# Rezoning Transportation Analysis

Petition Number: 2024-018

Date	Description
03-27-24	First Review (KC)
04-24-24	Second Review (KC)

# RZ-1.0

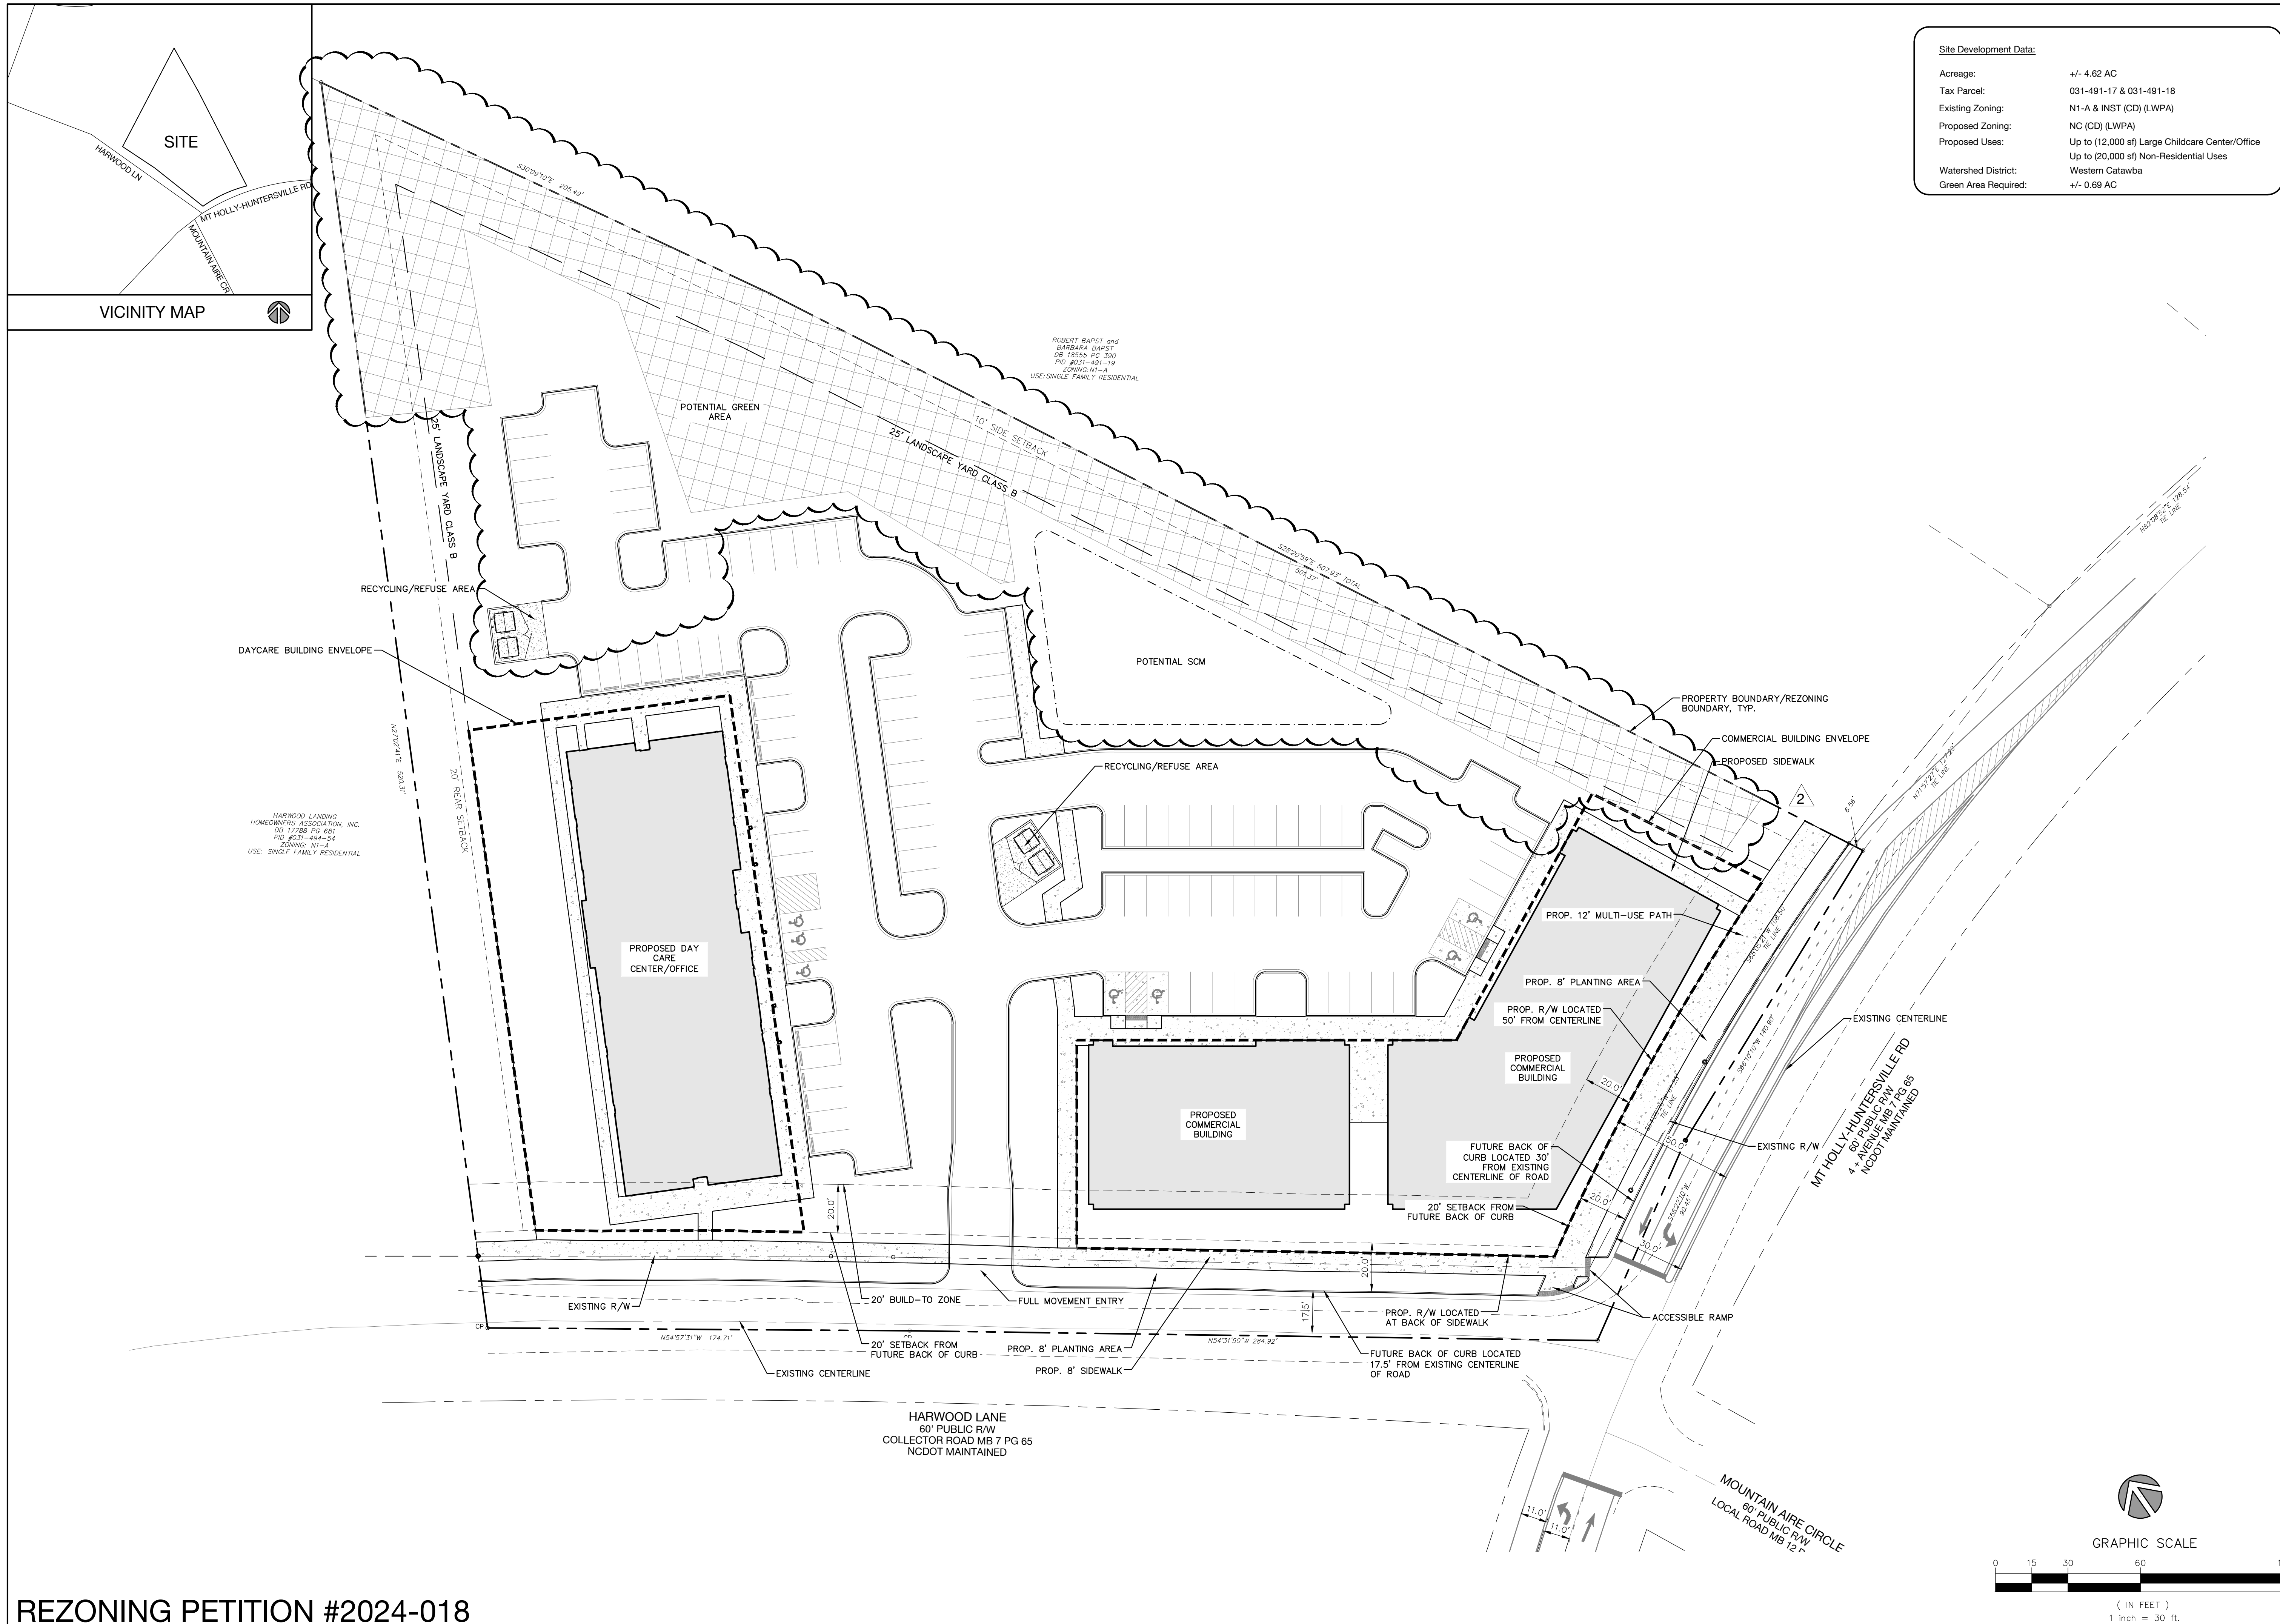
a. ~~**Mt Holly Huntersville Rd:** The future location of curb and gutter is 30' from centerline.~~

~~4+ Avenue, Shared Use Path per the Charlotte Streets Map~~

b. ~~**Harwood Lane:** The future location of curb and gutter is 17.5' from centerline.~~

~~CLDSM standard Local Collector Street U-07B~~

~~Label and dimension the curb and gutter from the centerline for each road on the site plan. Show proposed striping layout for Mt Holly Huntersville Road and commit to restriping for left turn lane on Mt Holly Huntersville Road at Harwood Lane.~~
